24 May 2019

File No: 2019/240934
Our Ref: R/2017/18/B
Your Ref: SSD 8665

Response to Submissions – Refurbishment of the Mercantile Hotel including new rooftop bar and variation to SCRA Scheme (SSD 8665)

Drawing Title
South Elevation

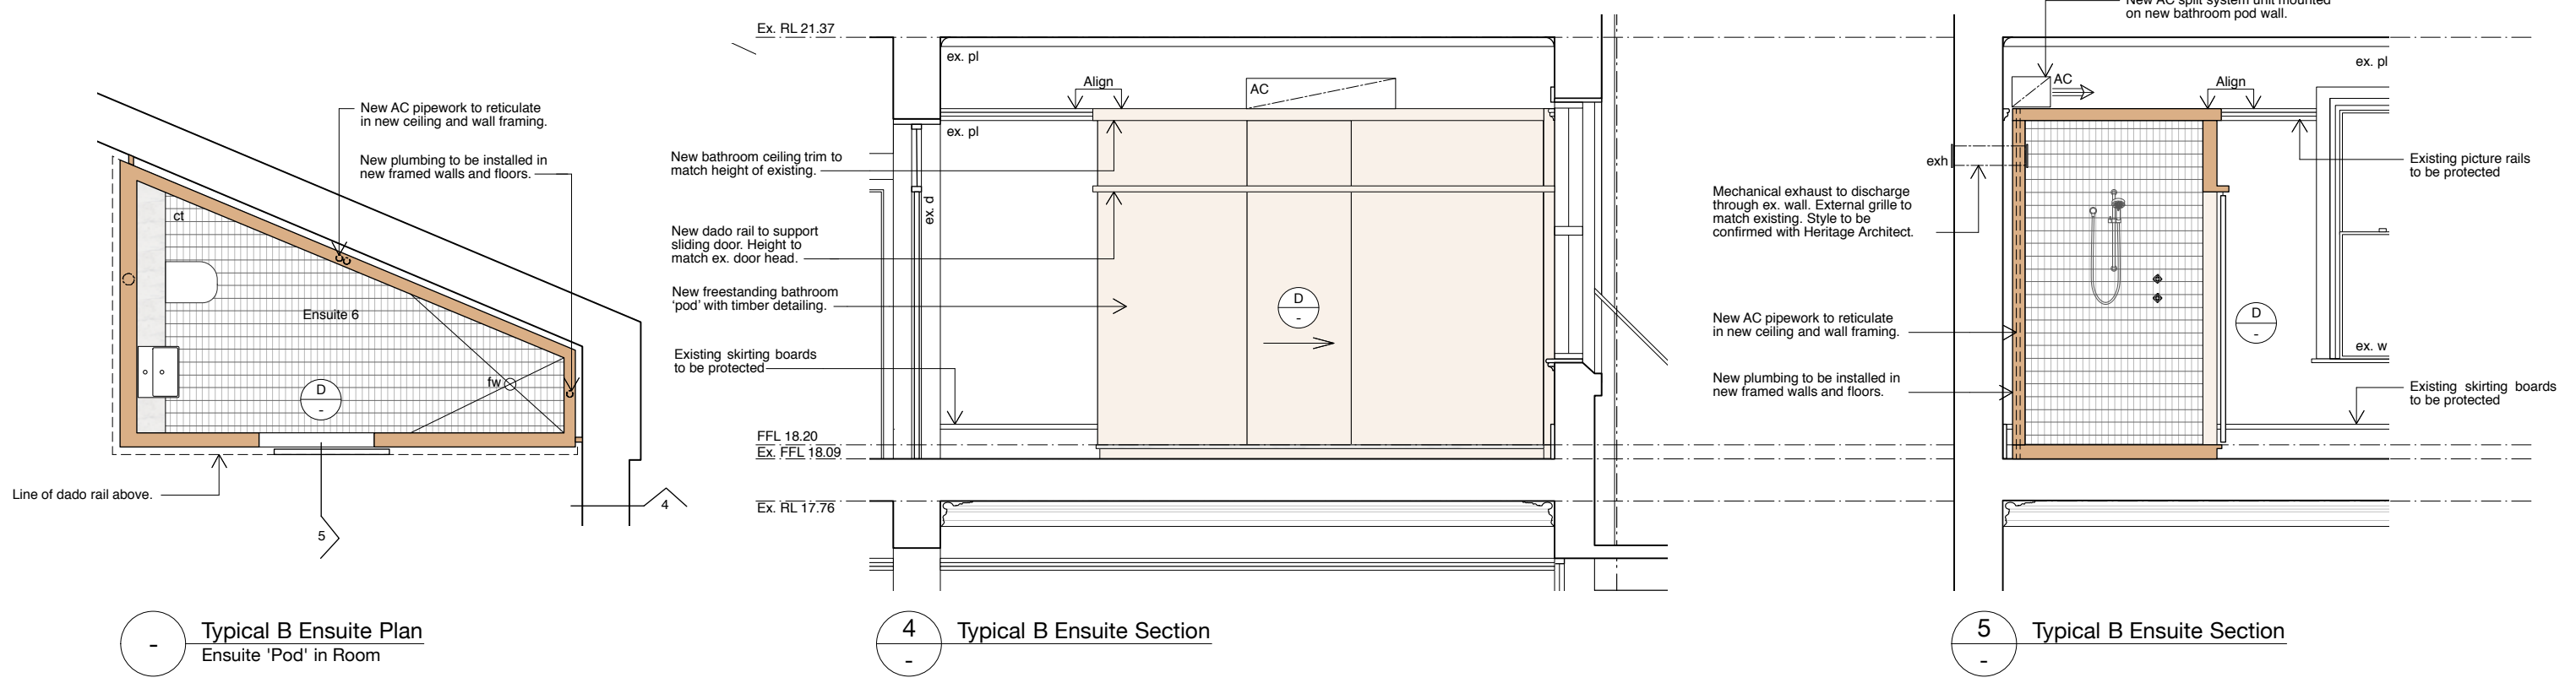
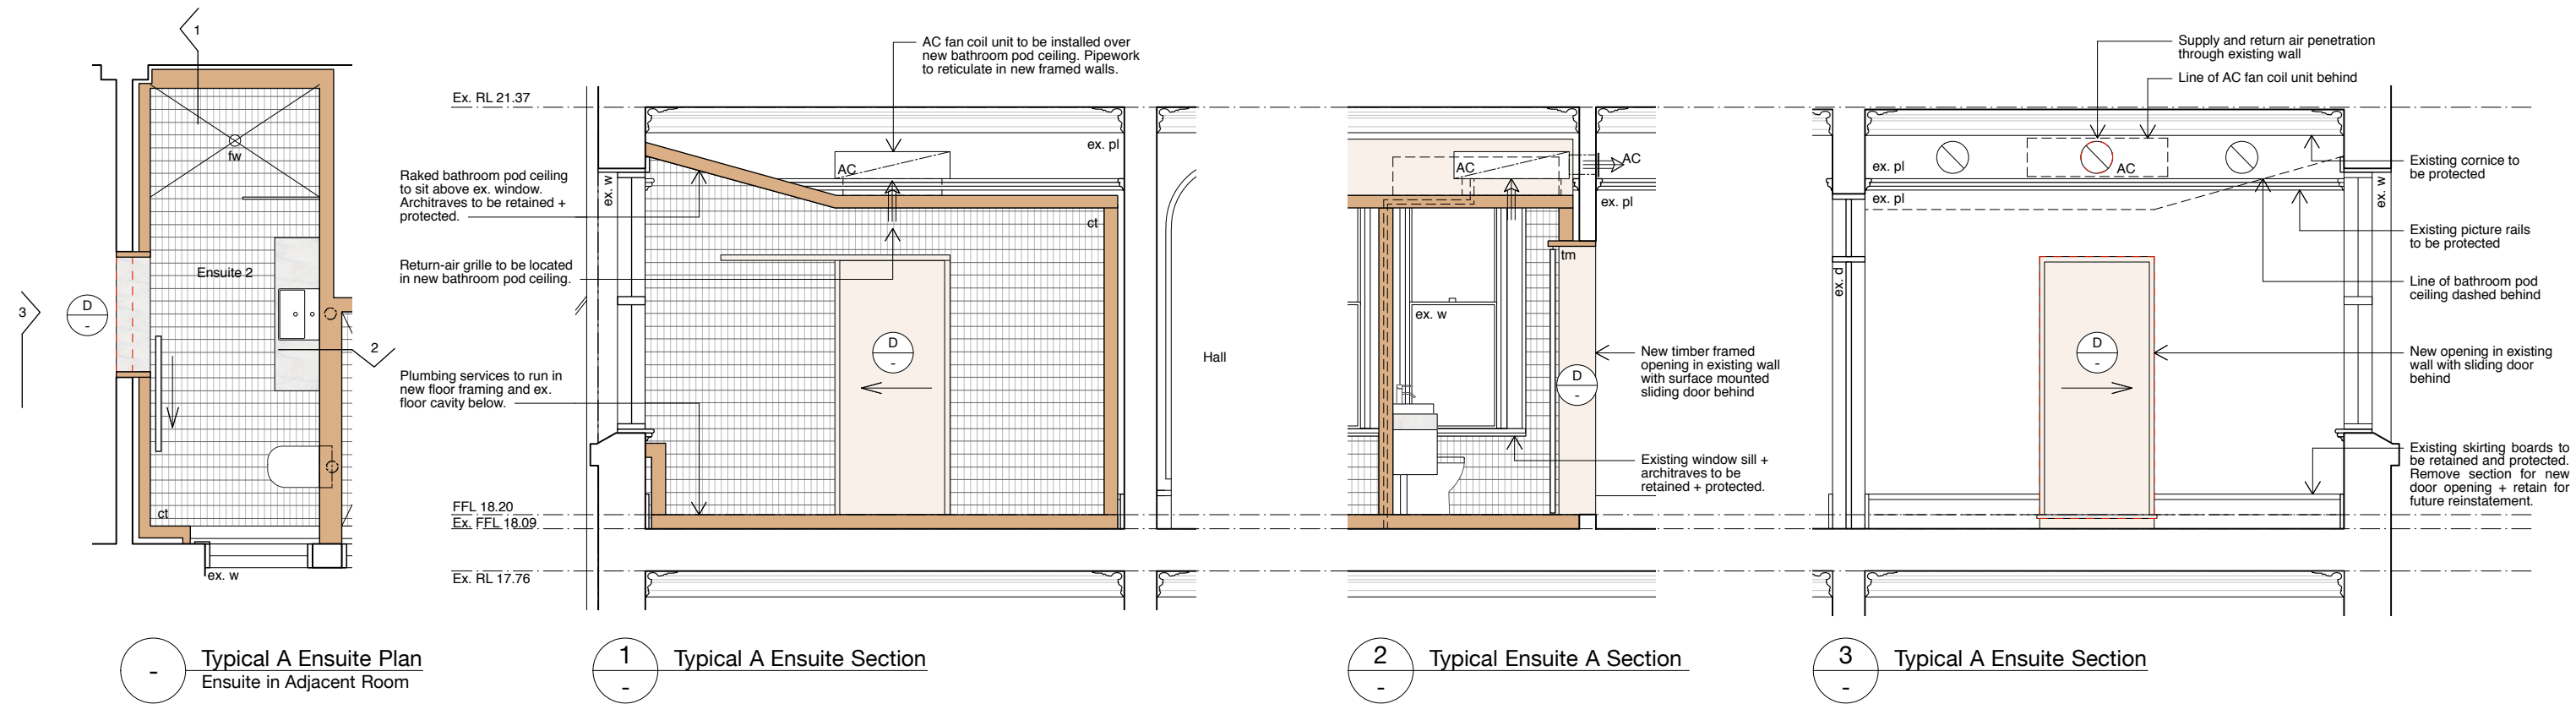
The City recommended the proponent provide a full schedule of materials, finishes and colours, keyed to elevations, be submitted for review. This has not been provided in the RTS. The simple 'Finishes Schedule' provided on the covering page of the architectural plans is not adequate given the significance and prominence of the site. The elevation drawings also do not specify colours or materials proposed to the new works.

As originally requested the Department should require a full schedule of materials, finishes and colours, keyed to elevations with a high level of detail (i.e. identifying material, brand, model, colour specifications etc.).
